Application for a Non-Material Amendment Following a Grant of Planning Permission

Alterations to the front facade on the ground floor with full height glazed window and door to the existing shop including new timber door for the upper floor.

16/AP/5223

THE CHANGE TO OMIT THE 2ND DOOR AND REPLACE WITH THE CLEAR GLAZING (only one shop door)

Drawing No : 061/NOR/001 A

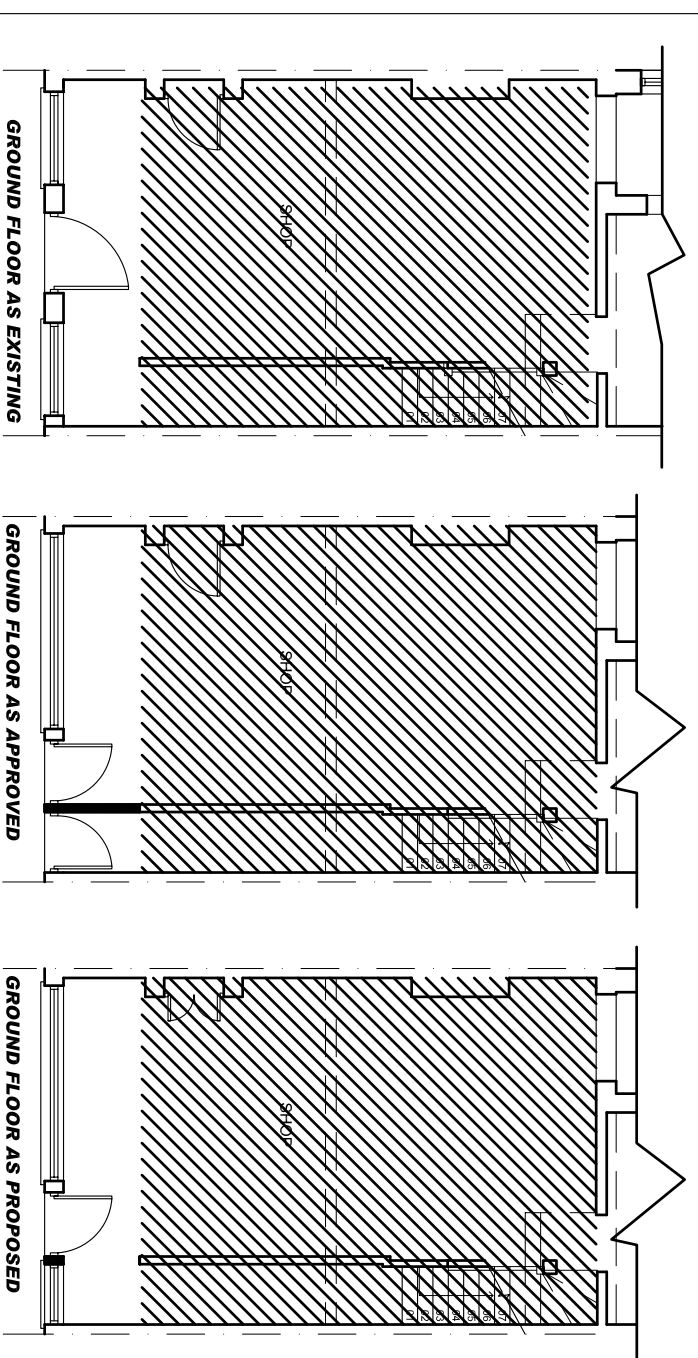
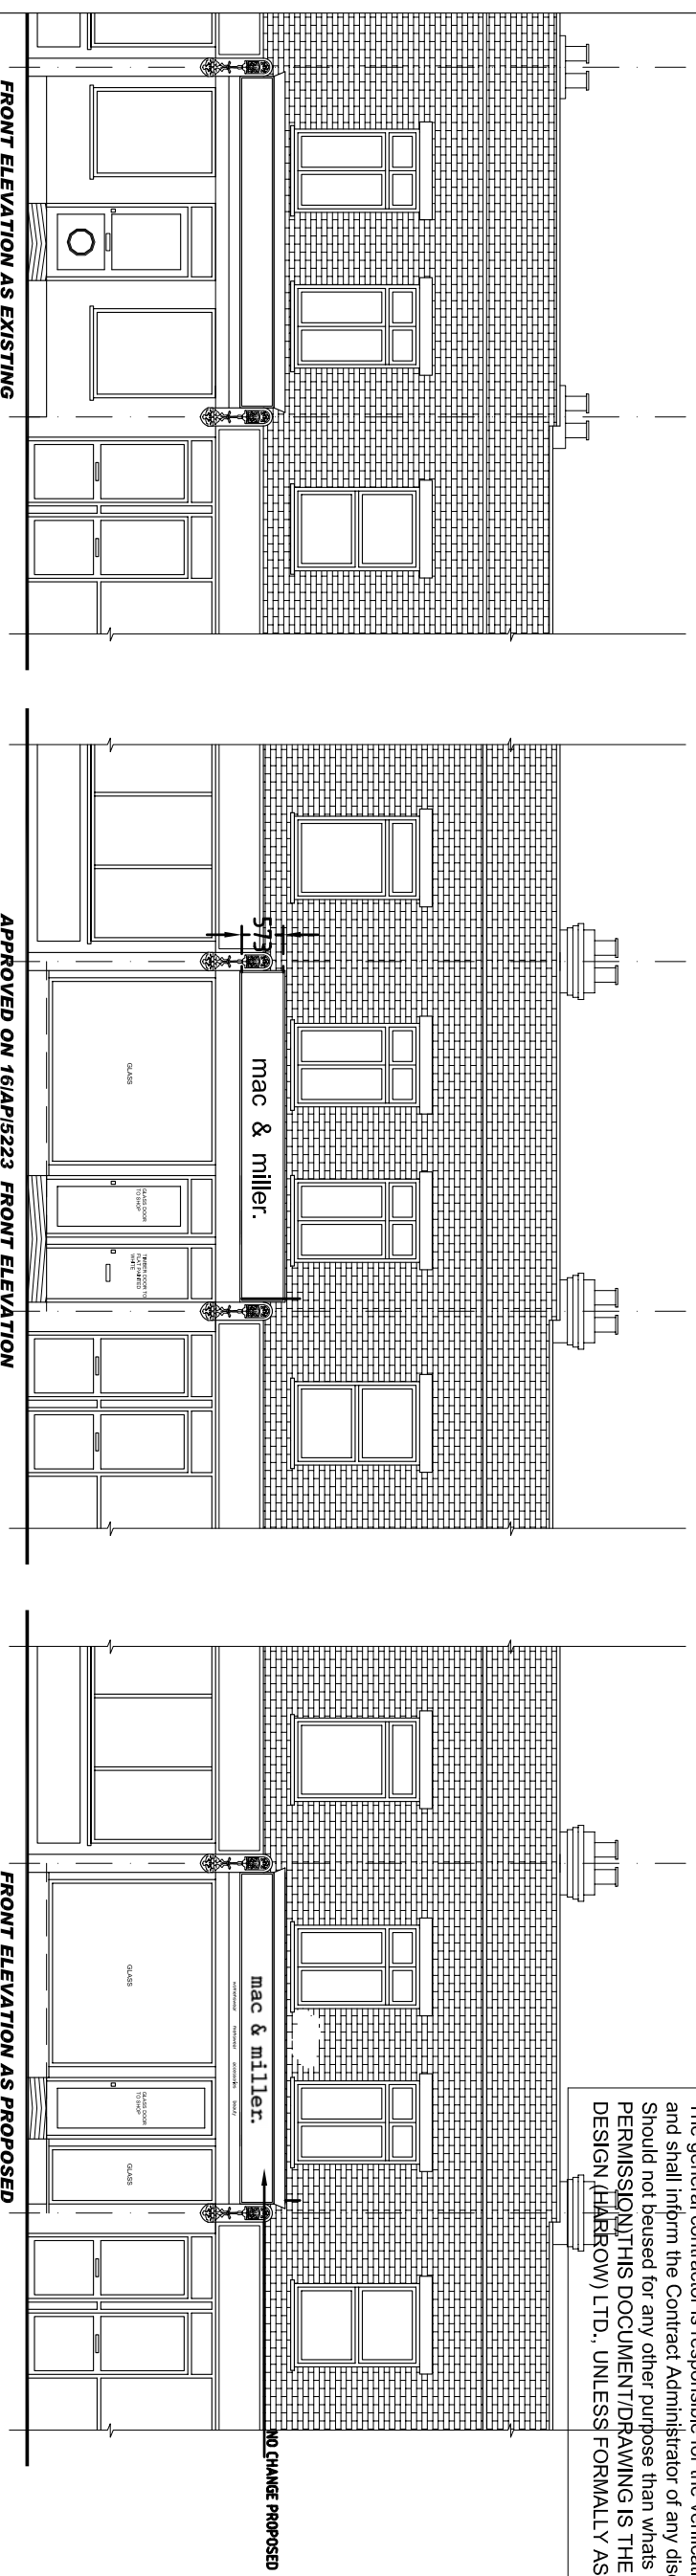
FOR THE SAFETY
